### **OFFICIAL NOTIFICATION OF DECISION**

Roland Gonzalez 335 Woodward Road SE Albuquerque, NM 87102 Project# PR-2022-006627 Application# MAJOR\_PLT-2025-00005 PRELIMINARY PLAT

# PR-2022-006627 June 11th, 2025 Notice of Decision - DHO

PLAT OF
LOTS 1 THRU 4
MARIOS CATERING

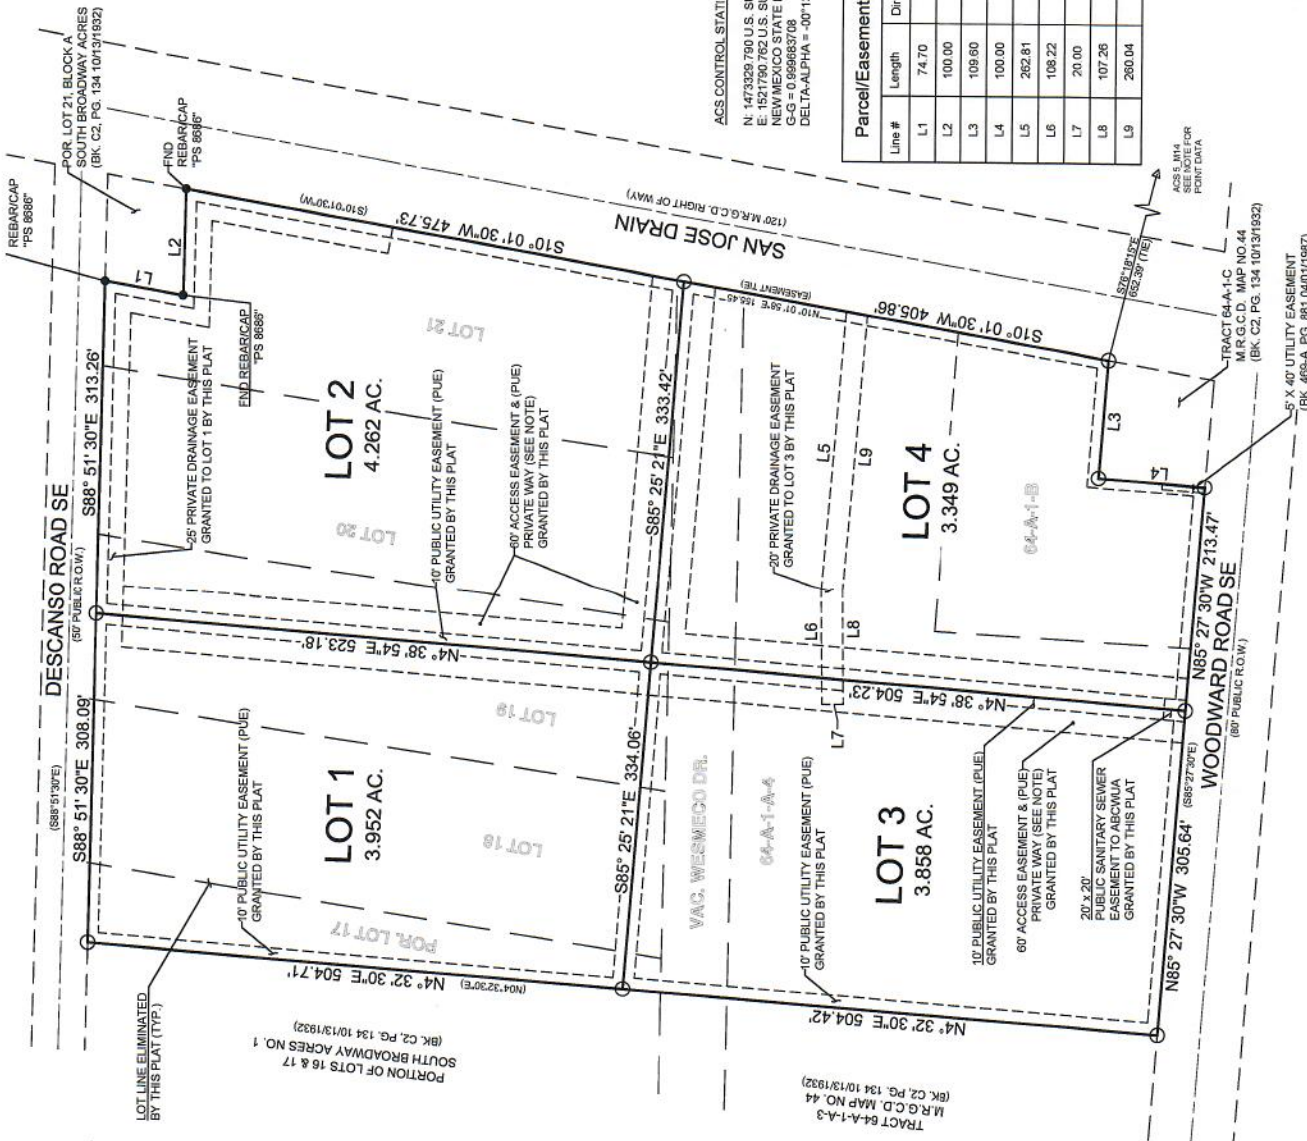
- d. Please include an appropriate easement from Descanso Road SE along the boundaries between proposed lot 1 and lot 2 as noted in the Availability Statement.
- e. Include the following note on the cover sheet of the proposed plat: ABCWUA Public Water & Sanitary Sewer Easements (ABCWUA)
